Our ref: HA/2017/119859/02-L01
Your ref: LU/323/17/PL
Date: 16 January 2018

FURTHER INFORMATION - CHANGE OF USE OF FORMER UNITED SERVICES CLUB (SUI GENERIS) TO 10 NO. FLATS (C3 DWELLING HOUSE) WITH ASSOCIATED LANDSCAPING, PARKING, BINS & RECYCLING STORAGE.

UNITED SERVICES MALTRAVERS ROAD LITTLEHAMPTON BN17 5NA

Ground Floor Plan

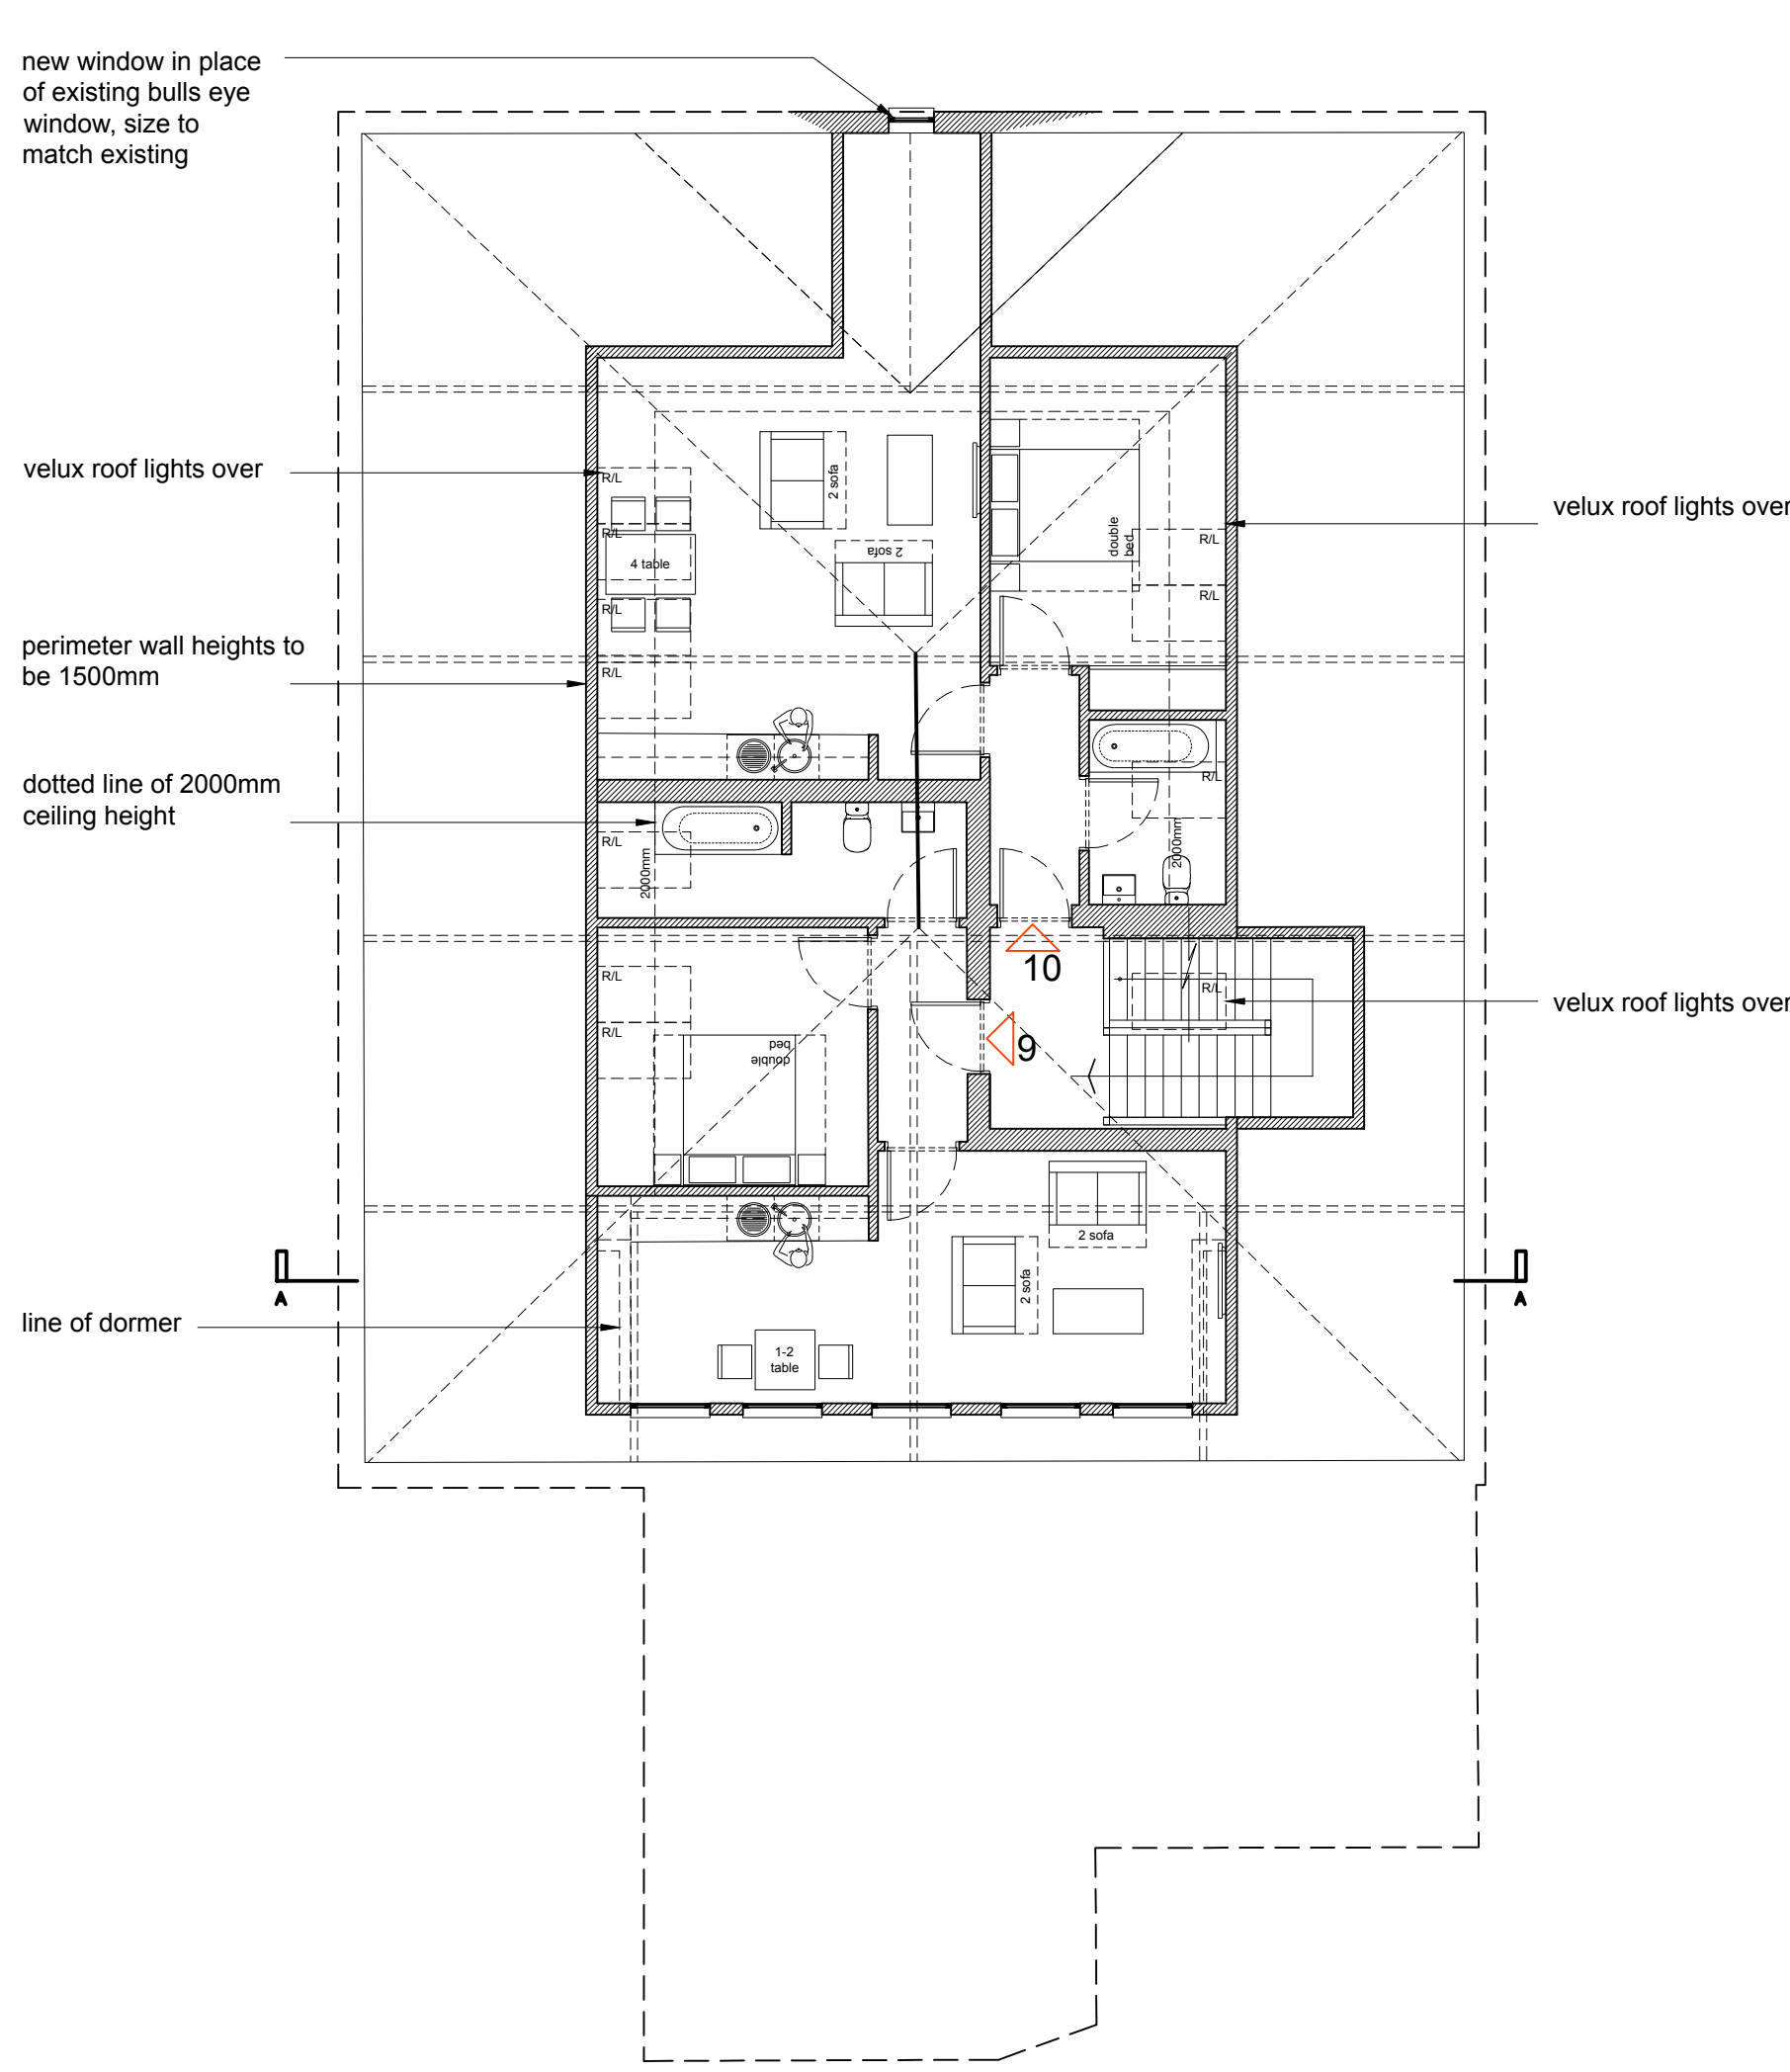
The proposed development will only meet the requirements of the National Planning Policy Framework if the following measure(s) as detailed in the Flood Risk Assessment (December 2017) and Proposed Building Plans (ref. 0041.PL.002A and 0041.PL.003B, September 2017) and submitted with this application are implemented and secured by way of a planning condition on any planning permission.

- **Finished floor levels are set no lower than 5.20 metres above Ordnance Datum (AOD).**
